CITY OF ALBUQUERQUE
DEVELOPMENT REVIEW BOARD

M I N U T E S

December 18, 2019

Agenda Item 1
Project Number 2019-002184-Site Plan

SHEET TITLE: CONCEPTUAL DRAINAGE PLAN

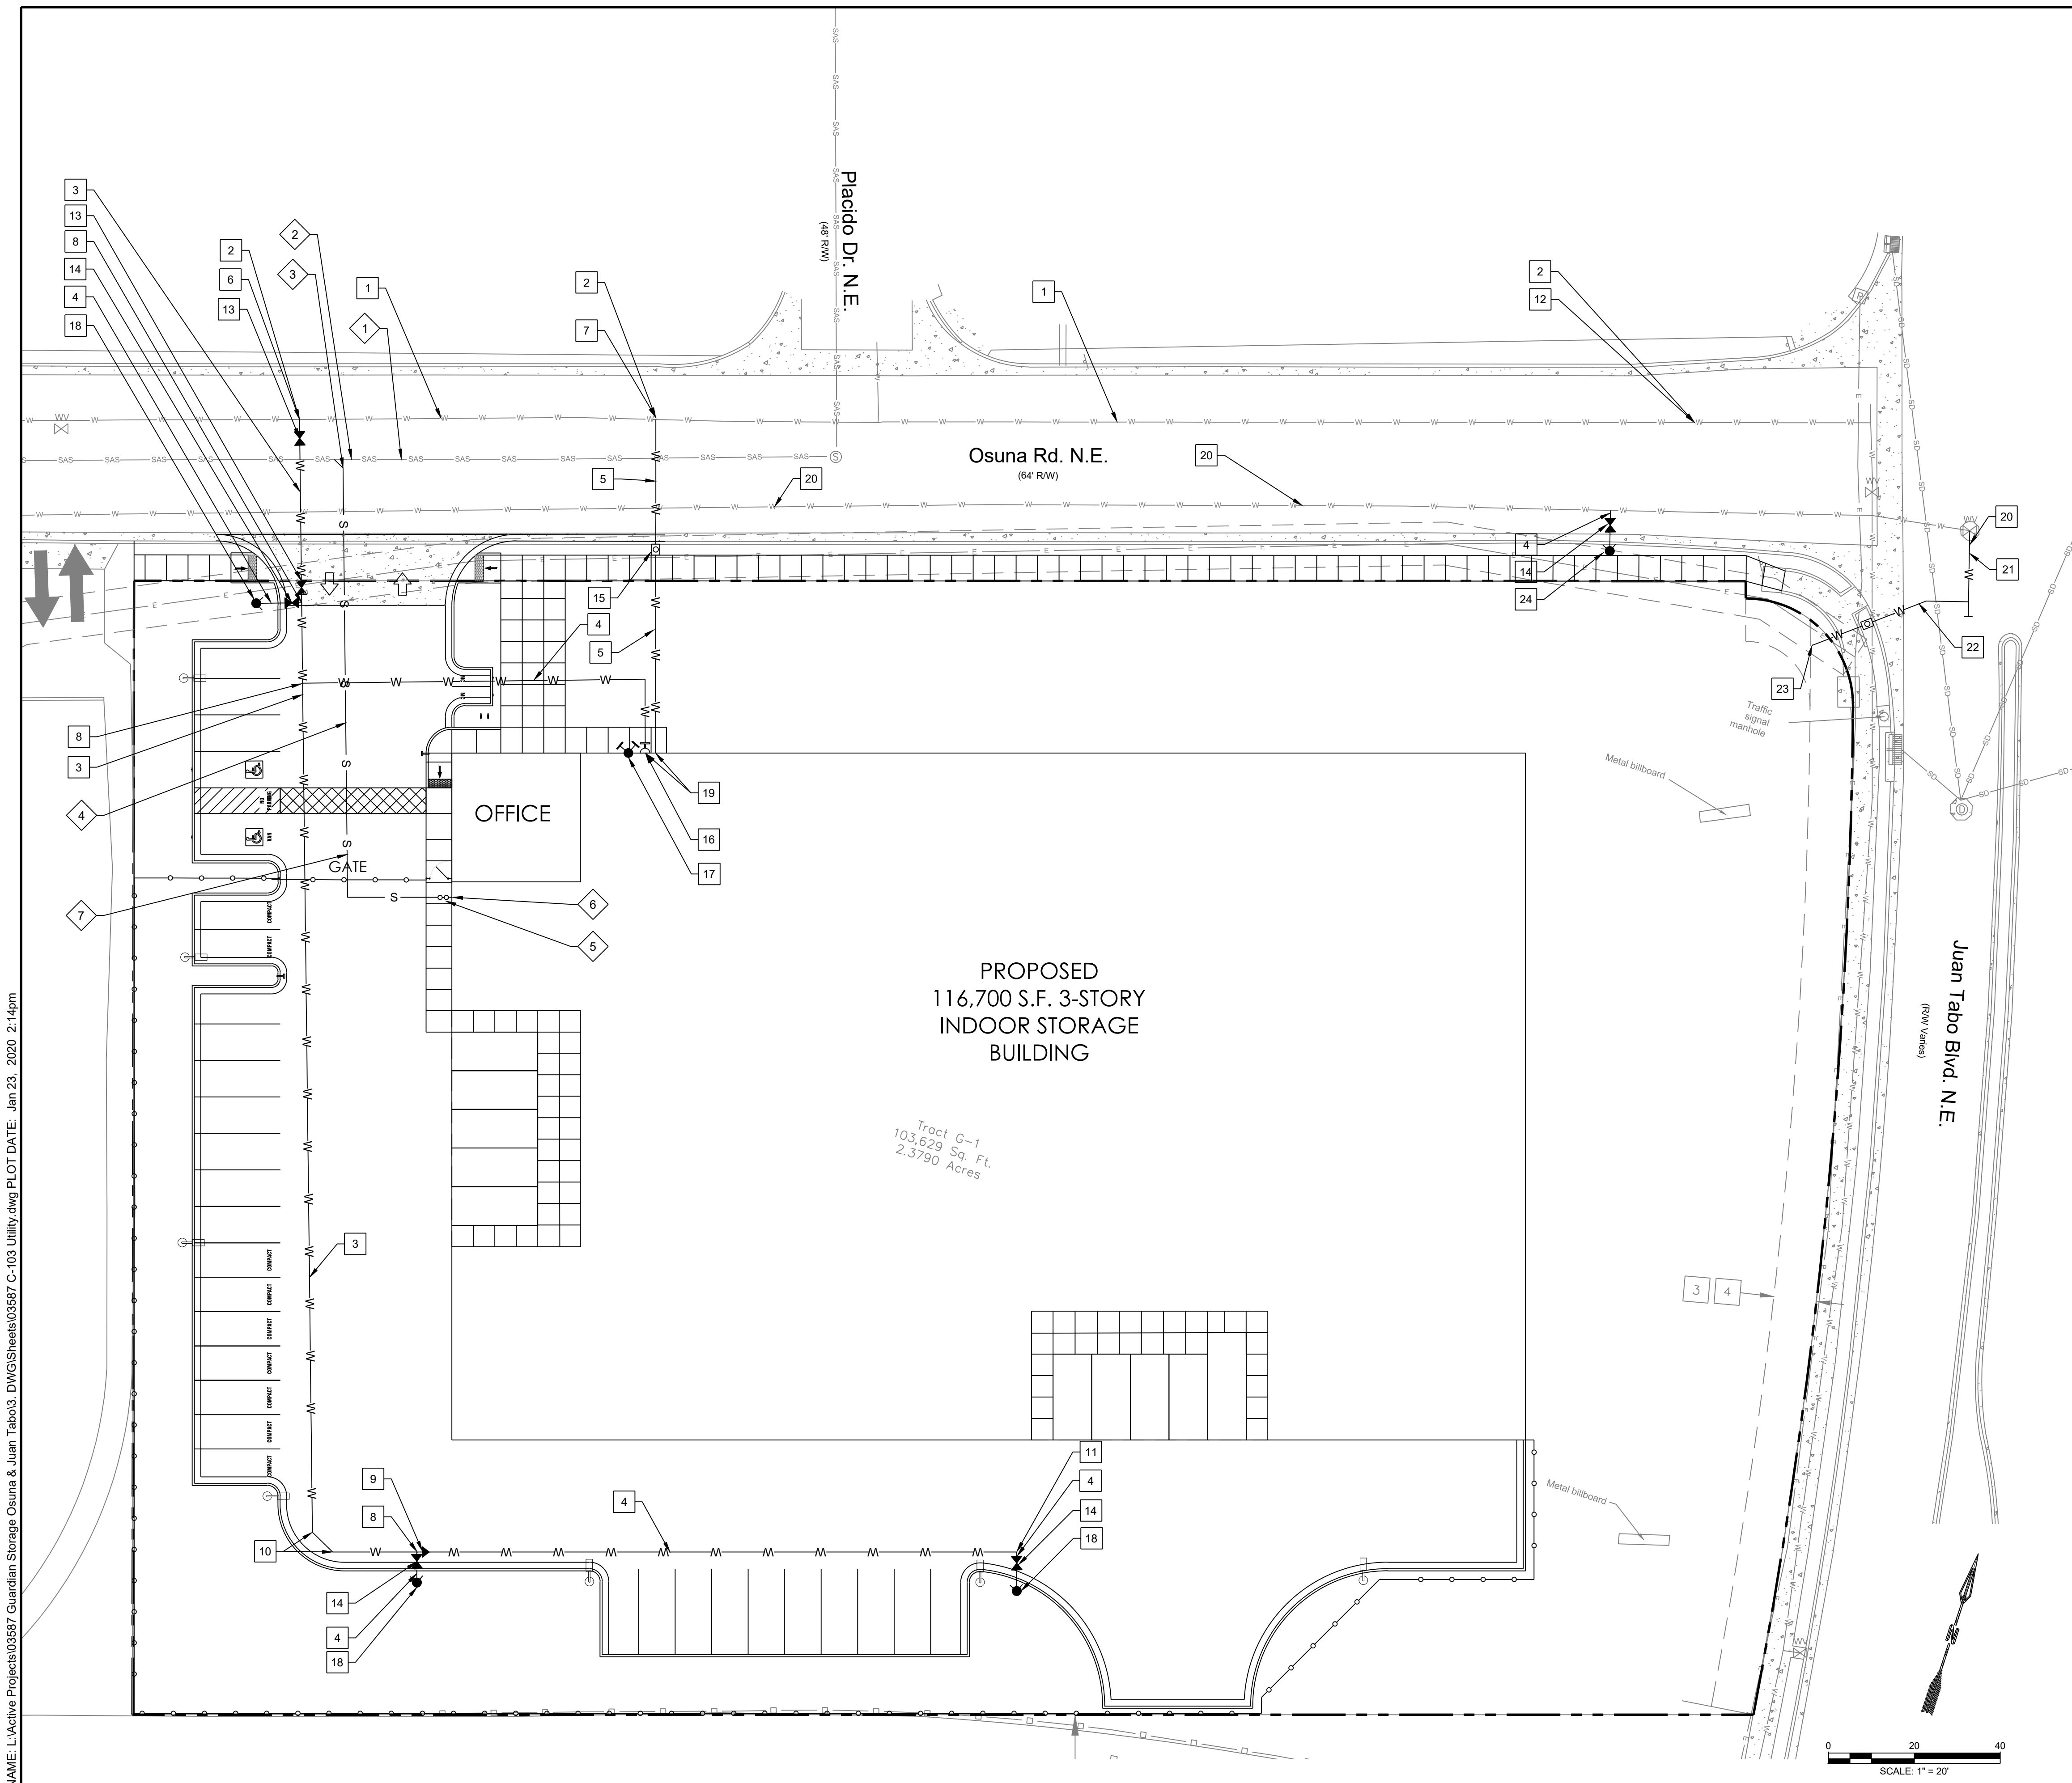
MR. CADENA: On-site waterline and fire hydrant shall be labeled "Private" on (inaudible). And (inaudible) correspondence with respect -- there was previous discussion about (inaudible) west (inaudible) grading and drainage plan. The existing flow, I think, was like four and a half cfs, and now going to the south drainage channel. And where, like, half the cfs is going up to the water property.

I noticed that there were steep slopes. I just wanted to see what your thoughts were for mitigating any possible erosion or high velocity (inaudible) very small, but (inaudible) engineer.

MR. GRIER: Yeah, we're greatly reducing the historic flow. There is -- there is some steep slopes there, and we're proposing a gravel surfacing on those slopes, together with the landscaping.

H WEST PROPERTY LINE SECTION
SCALE: NTS

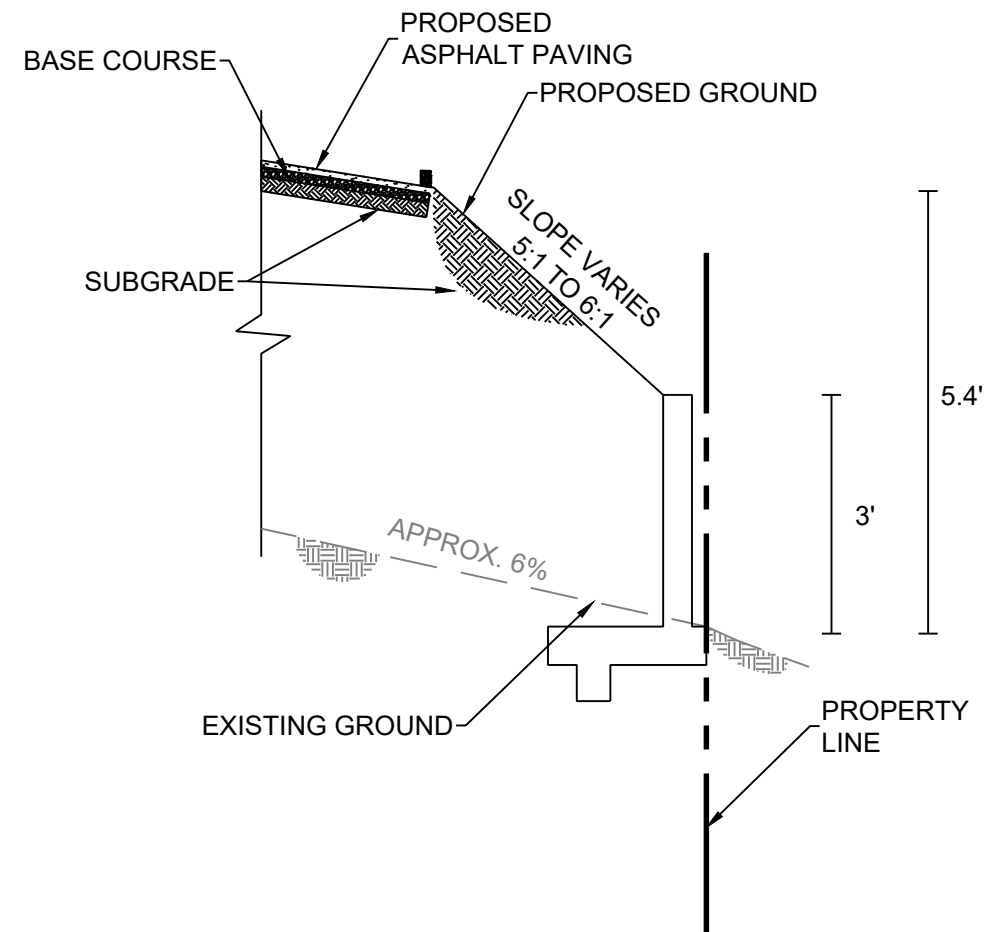
As you had mentioned, (inaudible) for self-storage for the use specific standards requires that no big wall or fence at least 6 feet or no more than 5, or (inaudible) buffer (inaudible), no wall (inaudible) shall be provided along the lot line that abuts residential zones. That is an R-1 zone, so you're going to have to put that opaque wall.

MR. MARTINEZ: So I wasn't sure from the (inaudible) description if that was an opaque wall.

MR. STROZIER: It was not. That was an oversight on our part. We -- we didn't -- you know, it's -- it's -- it's not -- it's zoned residential, but it's the water authority's (inaudible) and -- and (inaudible) improvement. So -- but we -- we will make that modification.

And -- and then the one question we -- we had on that, does that need to actually be on the property line, or can it be inset? And this is just based on kind of this conversation about how that edge is being treated and the adjacent trail and wanting to potentially have -- if the -- if the wall was -- was built in from the property line, it would create less of a tunnel along that -- the trail is kind of right along that edge of the property, and so that's -- that was just a question that we had when looking at -- at the implementation of the requirement.
